KITTITAS COUNTY

DEPARTMENT OF PUBLIC WORKS

MEMORANDUM

TO: All Staff
FROM: Public Works Plan Review Team
DATE: July 8, 2024
SUBJECT: BL-24-00013 Trust for Public Land - Tom Tyner

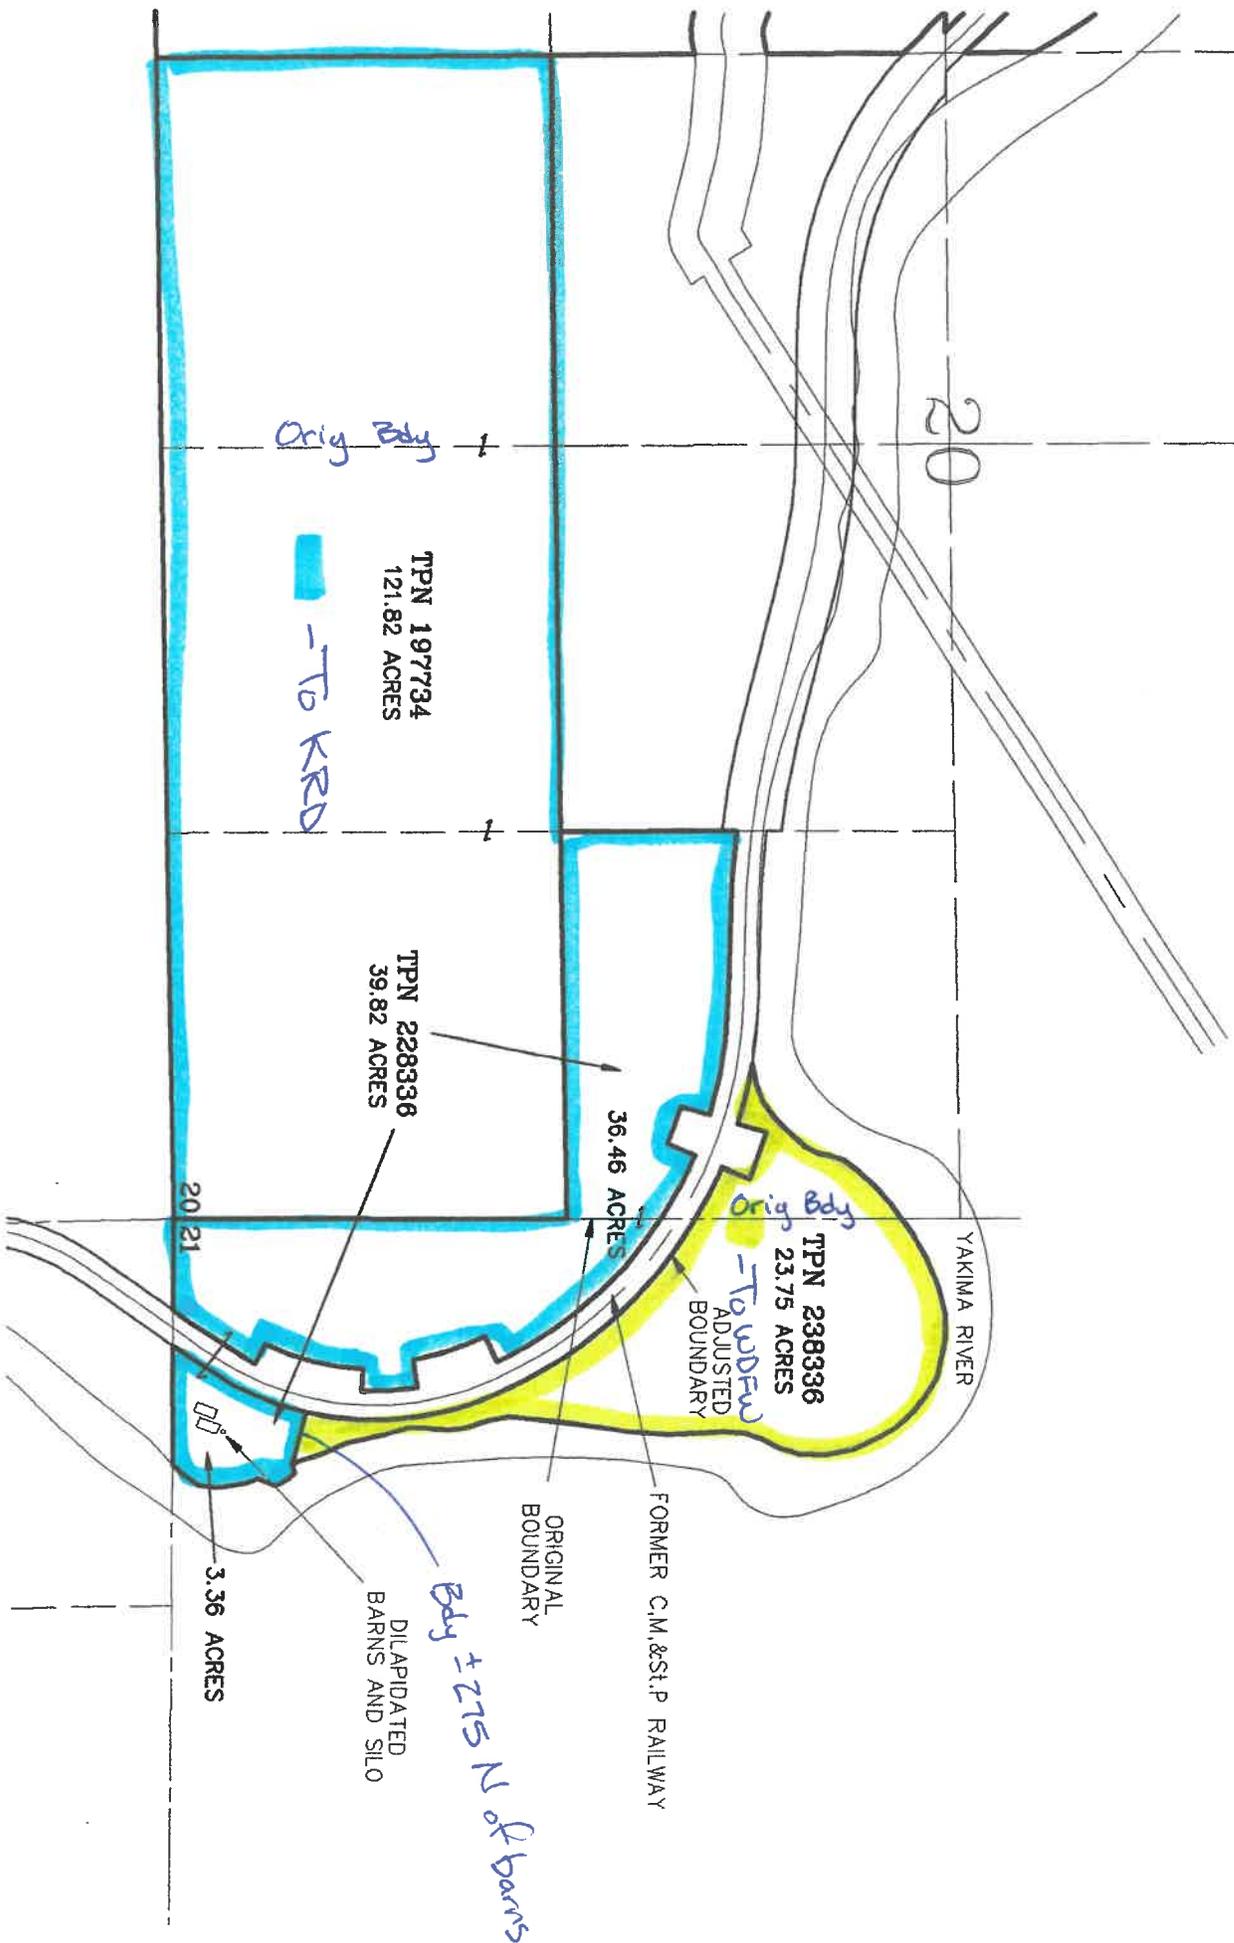
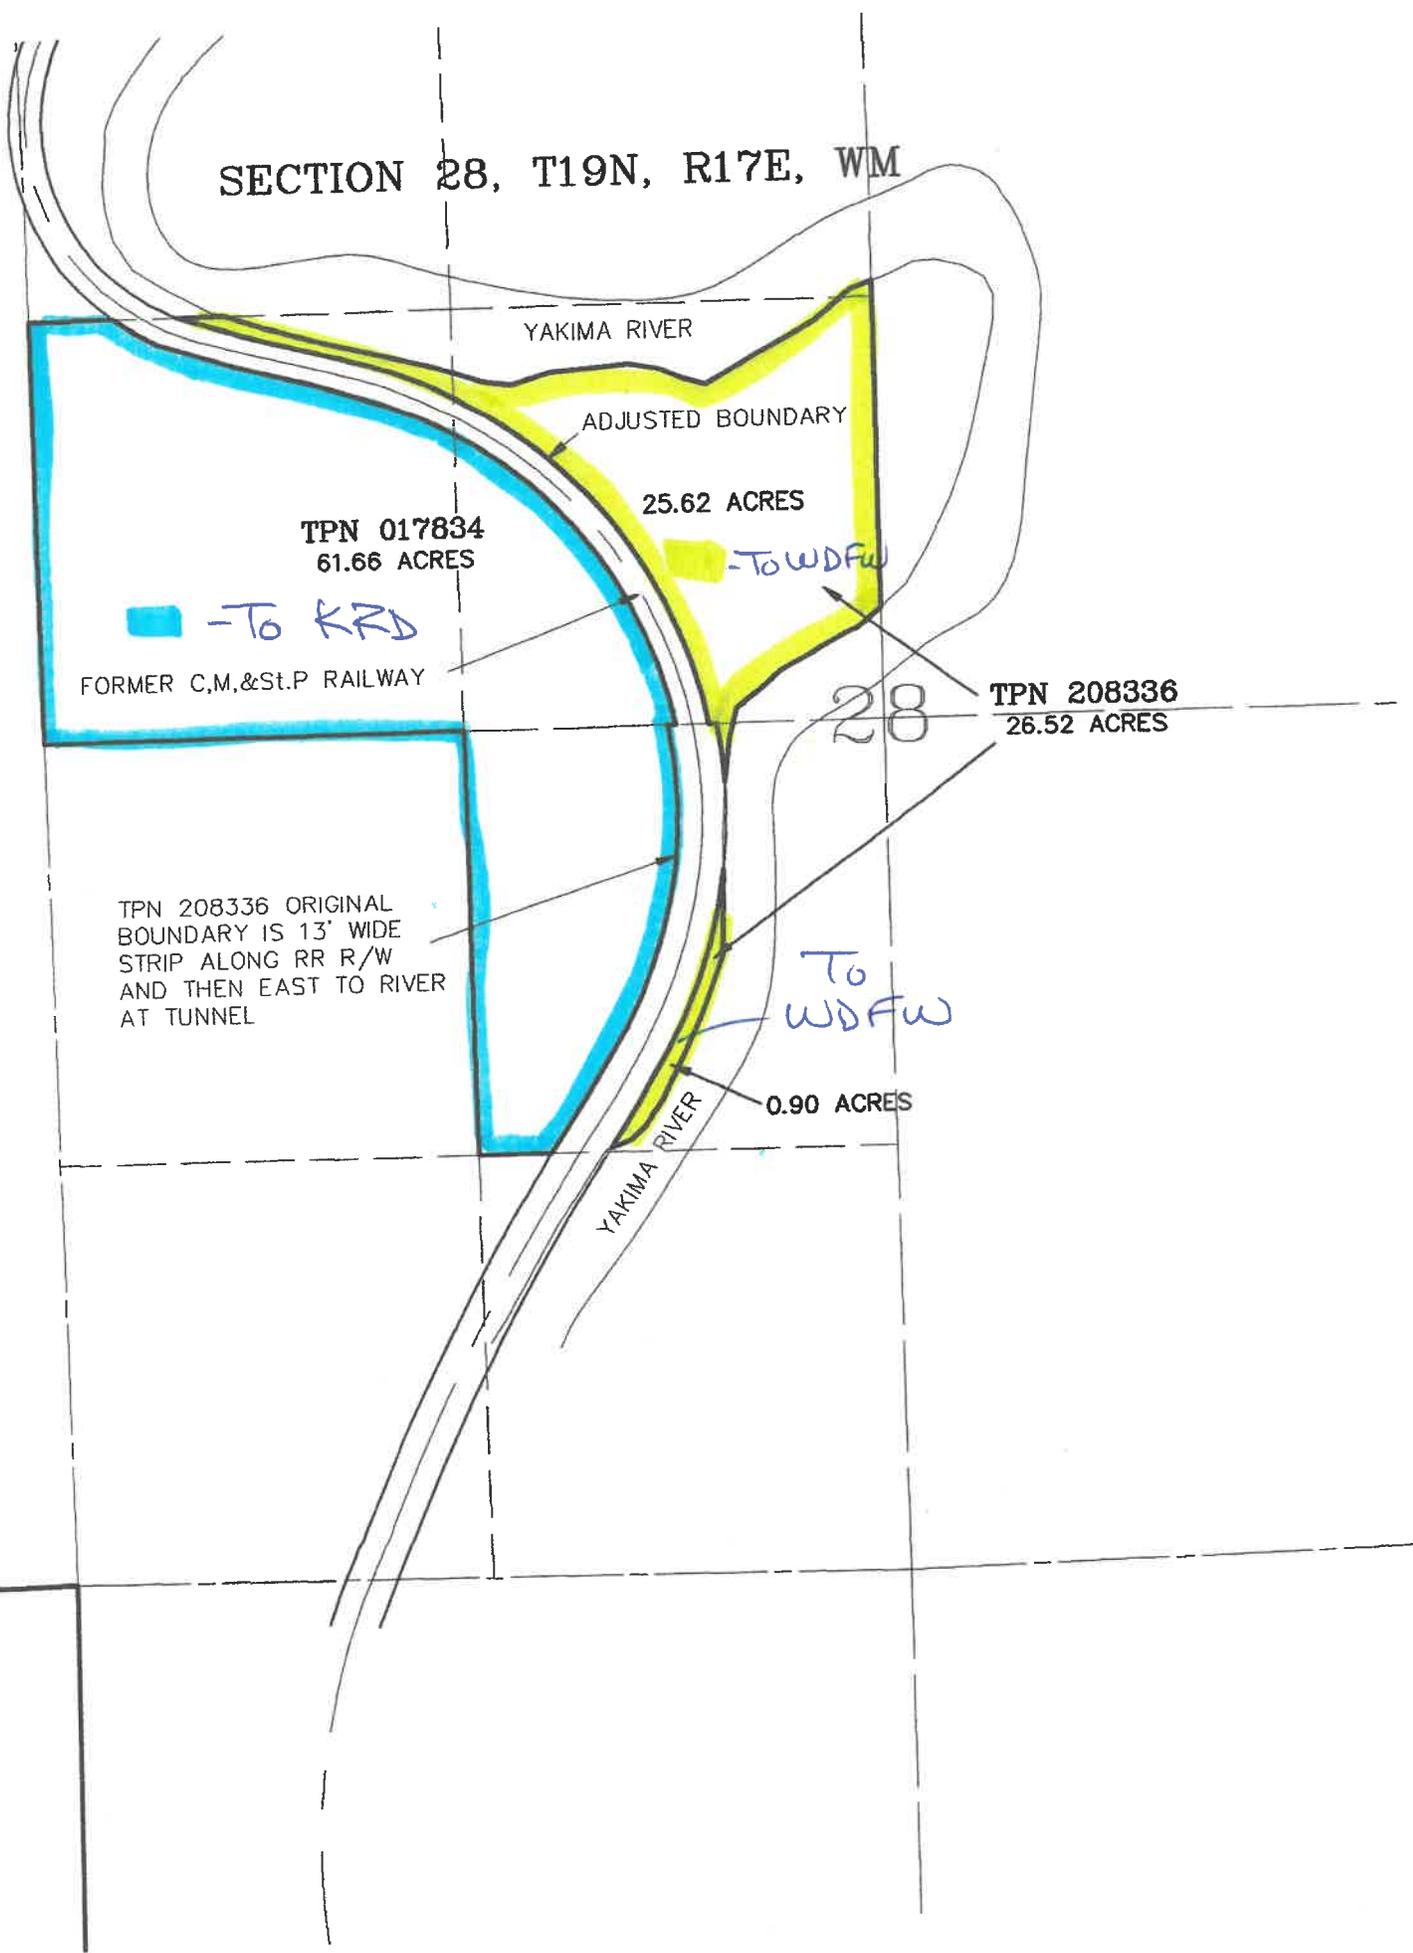
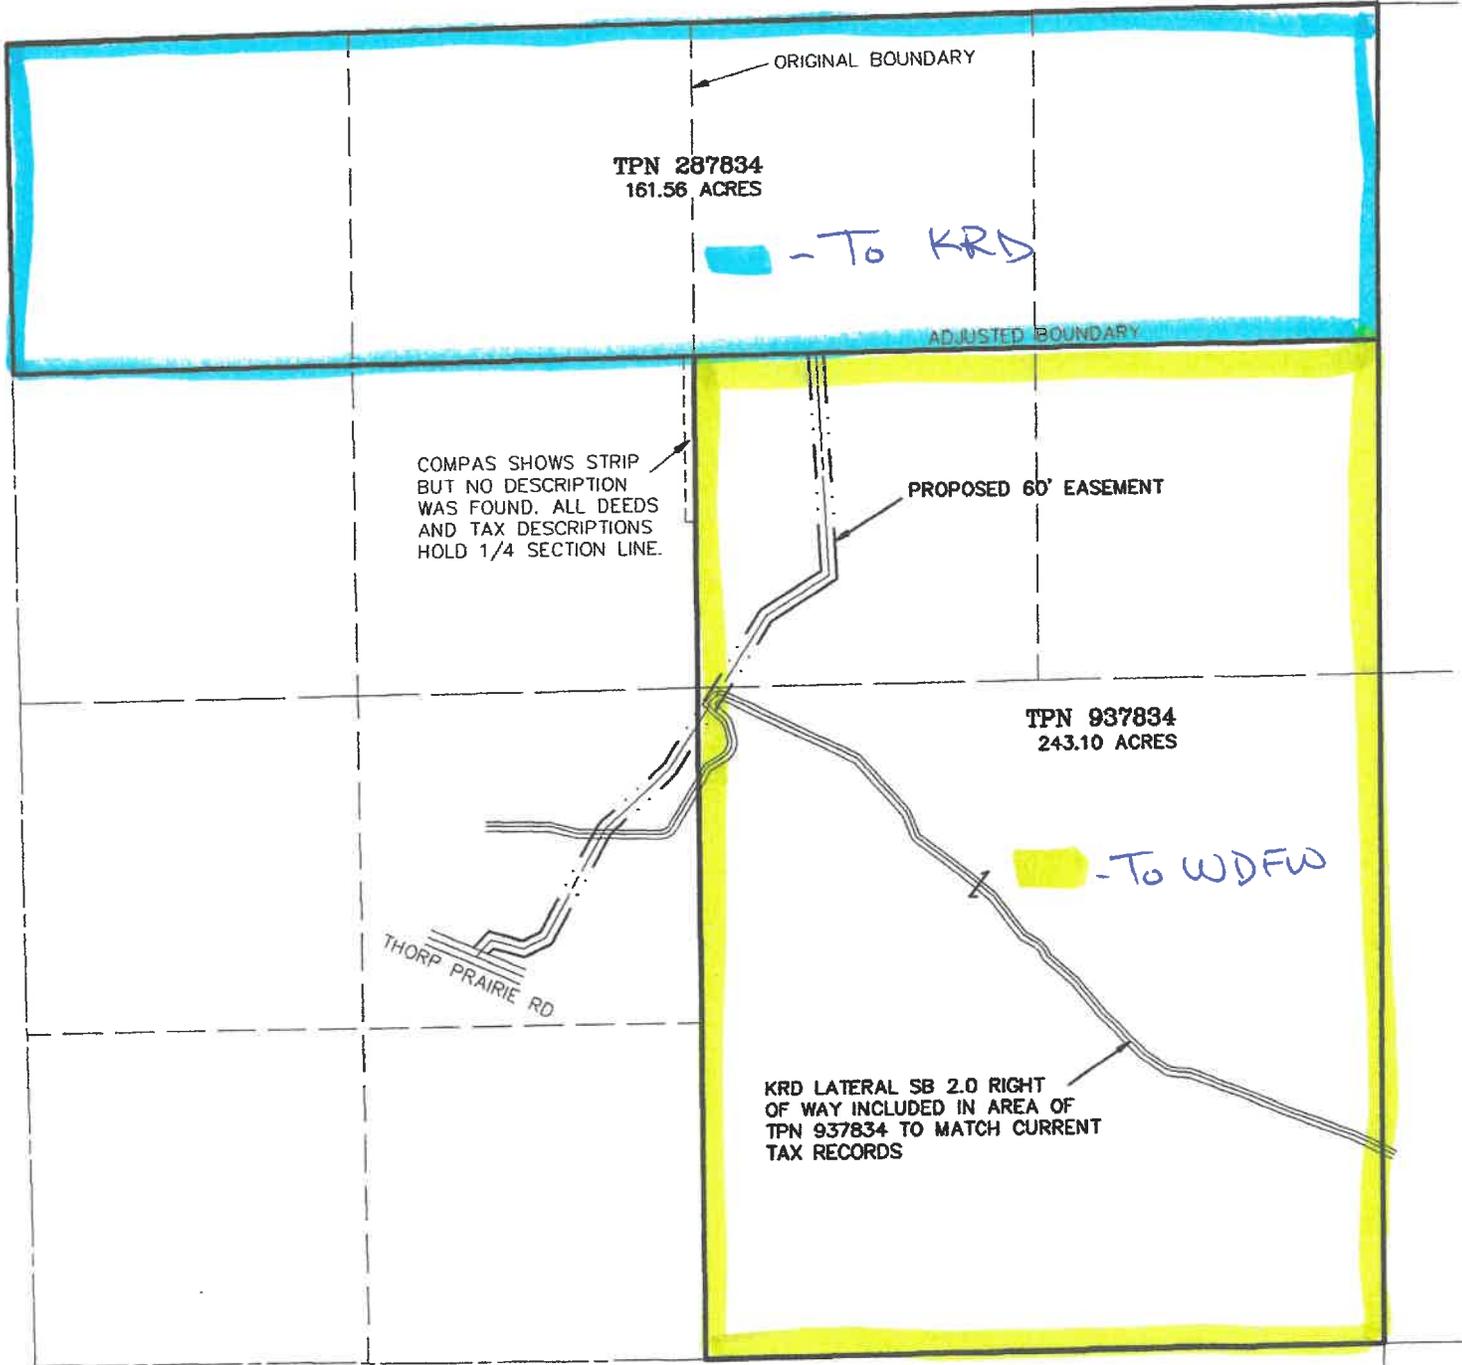
SURVEY	<p>As the application does not contain a survey map, comments are reserved until final. (KAH)</p> <p>UPDATE 08/13/2024</p> <ol style="list-style-type: none">1. The provided title report is incorrect in that it does not describe the subject lands. As such, existing legal descriptions and property burdens have not been reviewed. This will need to be corrected and reviewed before final approval.2. Where spirals are shown, sufficient information to recreate the spiral at centerline will need to be provided. In instances where BS,BC,EC, and ES can be used to determine spiral length, the only thing that would need to be included would be the spiral rate of change ('a' value). For offsets to c/l spiral (edge of R/W), nothing additionally is needed.3. Please show all roadways with r/w width, ownership and surfacing. Please note Horlick Rd is missing from Sheet 2.4. At a minimum, the new division lines will need to be staked in the field and corners shown on the face of the map. Where the new property corner is coincident with a missing section corner, a survey marker stamped in accordance with the Manual of Survey instructions shall be set.5. Please include language for Easement Z identifying its purpose together with "to be created via separate document". <p>OF NOTE (no changes required)</p> <p>Including the Arc dimensions for the West side of Parcel E on sheet 7 would be beneficial. While this data appears on sheet 5, it is the only dimension for Parcel E occurring on that page. (JT)</p>
